STATE SIGNIFICANT DEVELOPMENT SSD-9750 – REQUEST FOR REVISED SECRETARY'S ENVIRONMENTAL ASSESSMENT REQUIREMENTS - WINFARTHING ROAD, MARULAN - MARULAN QUARRY (SSD-9750)

**Subject: Marulan Quarry, Winfarthing Road, Marulan (SSD 9750)
Request for SEARs**

Figure 1 Proposed intersection configuration

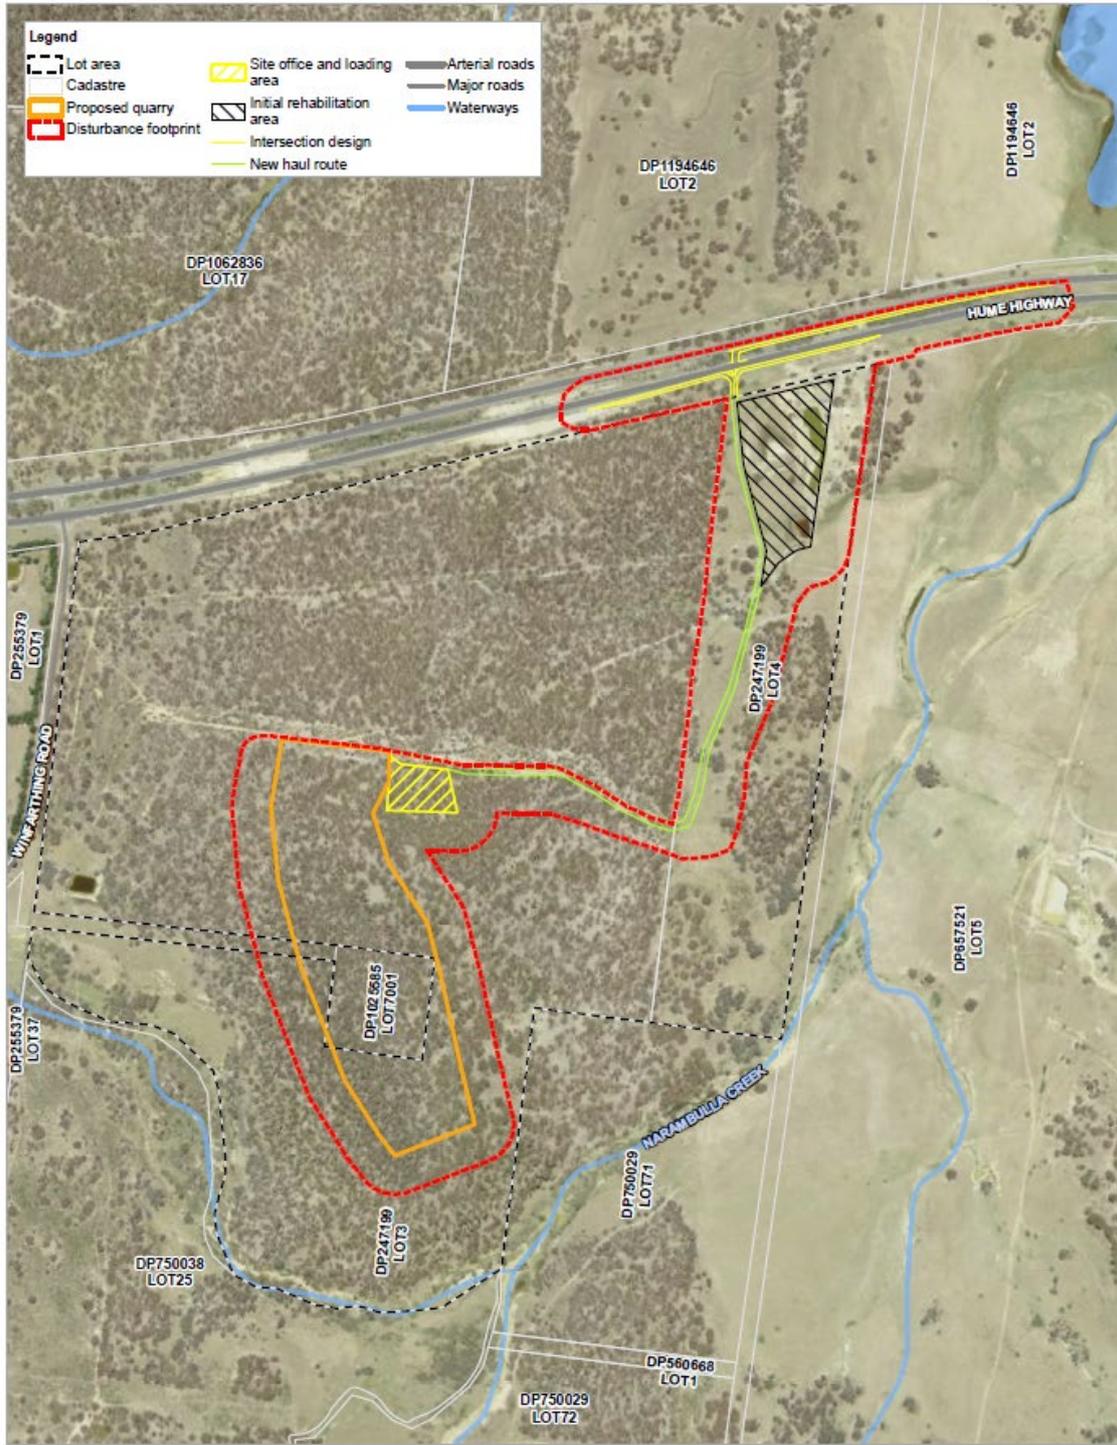
- Consideration of the impacts to the state road network and identification of appropriate measures to mitigate the impact.
- With specific reference to the proposed new site access (as detailed in the letter from GHD dated 16 December 2019 with reference 2127708-3916 and shown in Attachment 1 of this letter), to enable TfNSW to consider the suitability of the access arrangements proposed it will need to be demonstrated that:

- Appropriate measures to prevent right turns will be in place so as to ensure all trucks seeking to access the site from the west will do so by travelling to the South Marulan Interchange (as proposed).

- Appropriate and statutory binding measures will be in place to restrict the total truck movements access the site to the proposed maximum of:
 - 5 truck movements per hour and 50 truck movements per day entering the site.

- 5 truck movements per hour and 50 truck movements per day exiting the site.Details are required on how this will be achieved.
 - Safe intersection sight distance is available at the proposed access location and the any acceleration lane merge points (for a design speed of 120km/h).

- The designs (e.g. for the eastbound and westbound acceleration lanes as well as the west bound deceleration lane) must demonstrate they comply with the requirements in *Austroads Guide to Road design* and other applicable standards. While RMS notes the lengths required to accelerate heavy vehicles to the design speed is often impractical to achieve, consideration must be given to providing the lengths of these lanes to achieve the length required for a design speed of 120km/h. Where this is not able to be achieved, appropriate justification must be provided.

- The design for the eastbound acceleration lane must ensure a right turning vehicle entering the acceleration lane is adequately separated from the eastbound through lanes for at least the first 100m of the acceleration lane to allow adequate time for eastbound through vehicles to observe the turning vehicle and recognise it is utilising the acceleration lane (and not entering their lane). The distance is based on 3 seconds travel time for through vehicles at a design speed of 120km/h.

- The design for the westbound deceleration lane must not restrict sight distance for vehicles seeking to turn right out of the access and head east on the Hume Highway. In this regard, consideration needs to be given to a CHL type arrangement. The exit taper should also include the motorway type 'step out' marking shown in AS1742.2, Section 5.7.4.

- The proposed access arrangements adequately cater for the turning movements of the largest vehicle likely to make the movement. This needs to include a swept path analysis. In regards to the right turn movement from the access into the eastbound acceleration lane, the arrangements must demonstrate the design vehicle can safely cross the westbound Hume Highway lanes and then enter the eastbound acceleration lane without impacting eastbound through traffic on the Hume Highway (i.e. physically separate the eastbound acceleration and the eastbound lanes until the merge point).

- Any existing median opening impacted by a proposed acceleration lane (e.g. the eastbound acceleration lane) will be appropriately managed.
- Any existing access arrangements to properties in separate/private ownership that will be impacted must be identified and have be adequately assessed in terms of impacts.

- The intersection of the access with the Hume Highway will operate an acceptable level of service. Specifically, a SIDRA analysis which includes consideration of slow moving nature of trucks crossing the Hume Motorway to enter the acceleration lane (i.e. higher gap acceptance/follow up headway values based on truck clearance times at a similar junction with similar vehicles, e.g. Divalls Quarry on the Hume Highway around 400m east of Tiyces Lane, Boxers Creek) and a 10 year future scenario (to consider traffic growth on the Hume Highway).
